Prestons Waste Treatment Facility
Amendment Report

Appendix M

Previous EPA comments

Response to EPAs' comments from June, August and 4 December 2023

Figure 1-4 Proposed Site layout (indicative subject to detailed design)

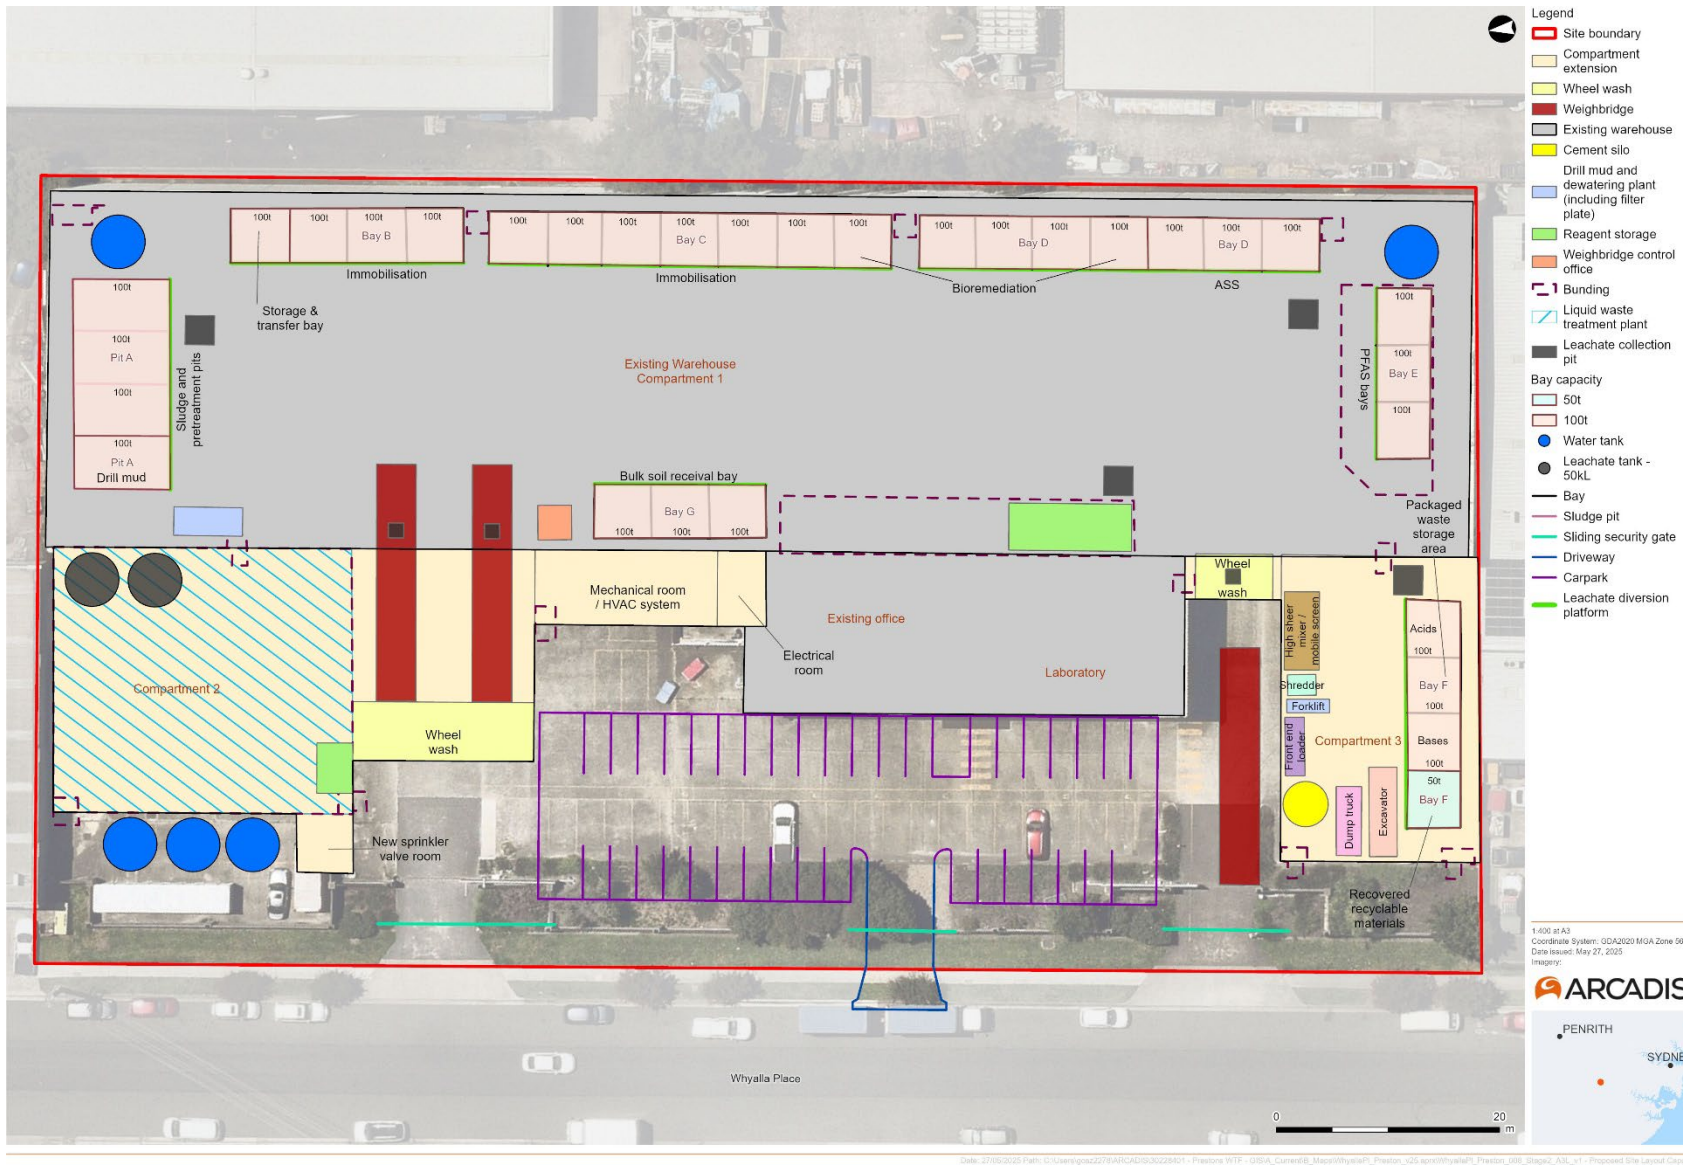
<p>4/12/2023 Where is the soil immobilisation to be carried out in the building?</p> <p>4/12/2023 Where would this immobilisation be carried out (in the bays?).</p>	<p>Soils to be treated via immobilisation would be stored in one of the immobilisation bays (Figure 1-4 in the Amended Proposal Description).</p> <p>As outlined in Section 6.2 of the OWMP (Appendix H), the material would be transferred from either the bulk receipt bay (Bay G) or from its storage bay to the high shear mixer within/adjacent to its storage bay, using an excavator and/or front-end loader. Once treated, the material would be directly transferred to its</p>	<p>Figure 1-4 in the Amended Proposal Description (Appendix B)</p>

<p>4/12/2023 The site plan does not identify the area to be used for bioremediation.</p>	<p>It is noted that the immobilisation and bioremediation bays may be interchangeable as all bays would be cleaned and decontaminated with Decon 90 or Liquinox after storage of each soil batch. Notwithstanding bays have been generally allocated within the Site Layout Plan and Figure 1-4 in the Amended Proposal</p>	<p>Figure 1-4 in the Amended Proposal Description (Appendix B)</p>

EPA Query (including date of query)	Response/Comment	Reference
	<p>Description labels the bays where bioremediation would occur, these are located along the eastern wall in Compartment 1.</p> <p>Bioremediation would occur in Bays C/D.</p>	
<p>4/12/2023 Appendix B – Section 1.4.7.2.3 – “Sludges with intermediate moisture content would undergo thickening using bentonite.”</p> <p>Where would the bentonite be mixed? In the containment bays or pits or as part of the LWTP?</p>	<p>Section 6.3.1 of the OWMP has been updated to clarify this process. The sludges would undergo thickening in the pits using bentonite. An excavator would be used to mix and incorporate the bentonite with the sludge.</p>	<p>Section 6.3.1 of the Draft OWMP (Appendix H)</p>
<p>4/12/2023 Appendix B – Section 1.4.7.2.3 – “Wet sludges would undergo filtration or flocculation to separate suspended solids. This may be done through the Dissolved Air Floatation (DAF) tank in the Liquid Waste Treatment Plant (LWTP).”</p> <ul style="list-style-type: none"> How much of <u>this</u> is proposed to be stored on site at any one time? 	<p>The sludge treatment procedure is provided in Section 6.3.1 of the OWMP. Reagents to be stored onsite are described in Section 1.5 of the Amended Proposal Description (Appendix B) and Section 6.7 of the OWMP. Reagents would be stored within the reagent storage areas. Following initial pre-treatment, the products (soil and liquid waste) would be re-assigned either a soil or liquid waste treatment train, depending on the contaminants present.</p>	<p>Section 6.3.1 and 6.7 of the Draft OWMP (Appendix H)</p> <p>Section 1.5 of the Amended Proposal Description (Appendix B)</p>

Figure 1-7: Site bunding and leachate treatment infrastructure (indicative subject to detailed design)

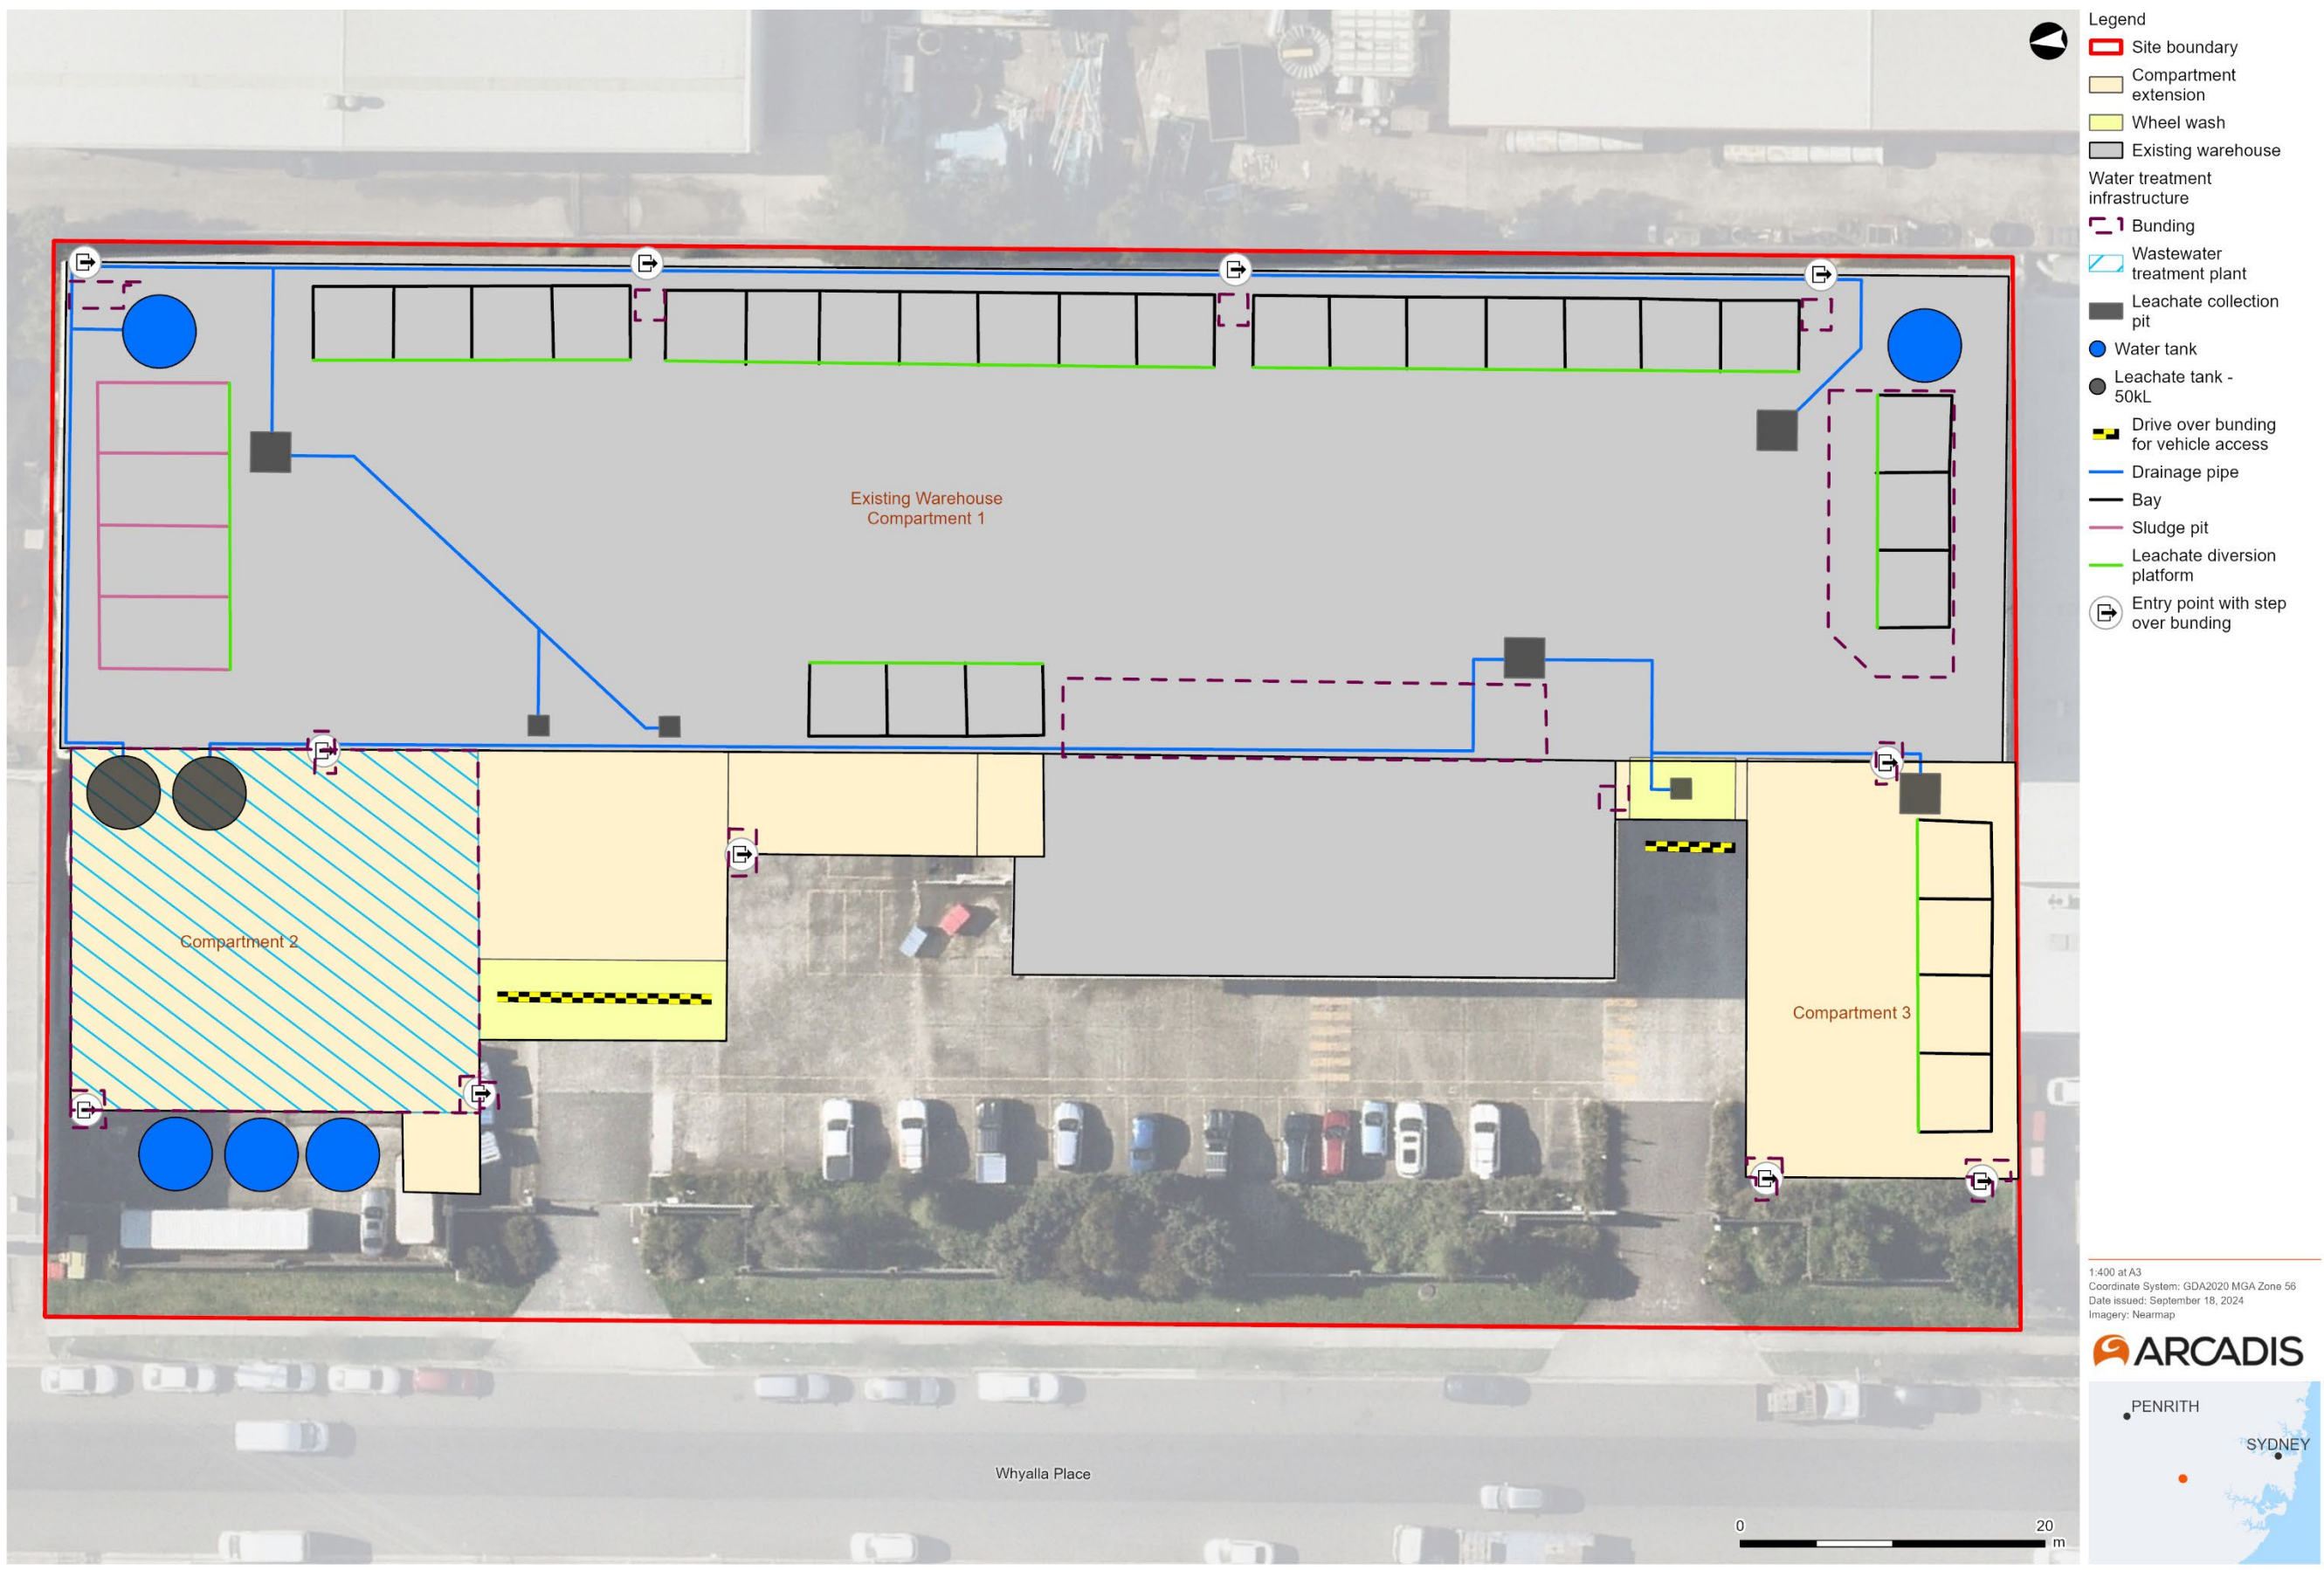
EPA Query (including date of query)	Response/Comment	Reference
Water and leachate management infrastructure		
<p>4/12/2023 The Department and the EPA have previously requested detailed plans for the proposed leachate and water management systems. The ADR at Figure 3.3 provides only a basic concept for the water and leachate management infrastructure which is laid over top of an aerial of the roof of the building. Although Section 3.3 of the ADR describes the proposed system, the applicant has not provided detailed plans to show that this system can work on site and what modifications to the existing hardstand areas and building are required to facilitate the system (creating necessary fall etc.). A detailed leachate and water management plan is required.</p> <p>4/12/2023 Section 1.2.8 of Appendix B suggests the leachate collection pits would be excavated into the ground and would involve ground-breaking internal to the warehouse building. What depth are the pits proposed to be provided at? What flood level would these pits be installed at?</p>	<p>An updated and consolidated set of plans have been prepared by SMEC for the proposed Facility and are provided in Appendix E of the Amendment Report.</p> <p>Drawing CC-201 shows where changes to existing hardstand would be required to install leachate management infrastructure. Cross Sections for Compartment 1 are provided in E5 Structural Design. Design Drawings E4 shows the design for the Hydraulics Services that would be installed as part of the Facility.</p> <p>Section 1.2.9 of the Amended Proposal Description (Appendix B) outlines the proposed leachate management system that would be installed at the Facility and includes a summary figure of the key leachate infrastructure features.</p> <p>Section 2.3.2 of the OEMP outlines how water and leachate will be managed.</p> <p>The Revised Environmental Management Measures (Appendix C) have been updated, such that G2 includes a commitment to prepare an Operational Stormwater and Leachate Management Plan.</p>	<p>Consolidated design drawings (Appendix E)</p> <p>Section 1.2.9 of the Amended Proposal Description (Appendix B)</p> <p>Section 2.3.2 of the draft OEMP (Appendix F)</p> <p>Revised Environmental Management Measures (Appendix C)</p>

<p>4/12/2023 Section 1.2.8 also suggests “The bunding would consist predominantly of drive-over bunding at the driveway entries and step-over bunding at doorways, with sufficient capacity to contain one tanker load of liquid (20,000 L)”, however this is not detailed on plans showing holding capacities. Also, no calculations or a water balance has been provided.</p> <p>Bunding of Wastewater Treatment Plant – Appendix B suggests the LWTP will be bunded in accordance with Australian Standards. Which standards is the Applicant referring to? What is the capacity of the bunded area and</p>	<p>Since the timing of this comment, Section 1.4.12 of the Amended Proposal Description (Appendix B) has been updated to provide clarity on the water balance for the site.</p> <p>The bunding design would be sufficient to contain the load of one 20,000L tanker truck, as described in Section 1.2.9 of the Amended Proposal description.</p> <p>Bunding for the facility has been designed to capture the firewater requirements as prescribed in AS2419.1, which is:</p> <ul style="list-style-type: none"> • Fire hydrant water supply of minimum 4 hours at 20L/s = 288 kL • Fire sprinkler water supply of minimum 2 hours at 96L/s (as per AS 2118.1-1999) = 691.2 kL <p>To capture the spent fire water the bunding would therefore require a minimum height of 178.4 mmm $(=(288\text{kL} + 691.2\text{kL}) \times 1,000 / 5,490)$. The proposed bunding is 250 mm in height, which would provide significantly more storage capacity than required to capture the spent fire water.</p>	<p>Section 1.2.9 and Section 1.4.12 of the Amended Proposal Description (Appendix B)</p> <p>Consolidated design drawings (Appendix E)</p>

EPA Query (including date of query)	Response/Comment	Reference
<p>how has this capacity been selected (failure of largest size vessel, containment of fire water etc.)</p> <p>Again, the basic plans provided do not provide the surety that the system described in the ADR and Proposal Description (Appendix B) can actually be catered for within the existing and expanded building.</p> <p>The information and plans provided is insufficient for the Department and the EPA to carry out an informed assessment of the development. The lack of detailed plans for this SSD has continually been raised as an issue with the Applicant. Examples of other the detailed plans submitted for other similar facilities have also been provided.</p>	<p>The total storage capacity provided by the bunding within the three compartments of the Facility is 1,283kL, comprising:</p> <ul style="list-style-type: none"> • Compartment 1: 1,007kL • Compartment 2: 156 kL • Compartment 3: 120kL. <p>An updated and consolidated set of plans has been prepared by SMEC for the proposed Facility and are provided in Appendix E of the Amendment Report.</p>
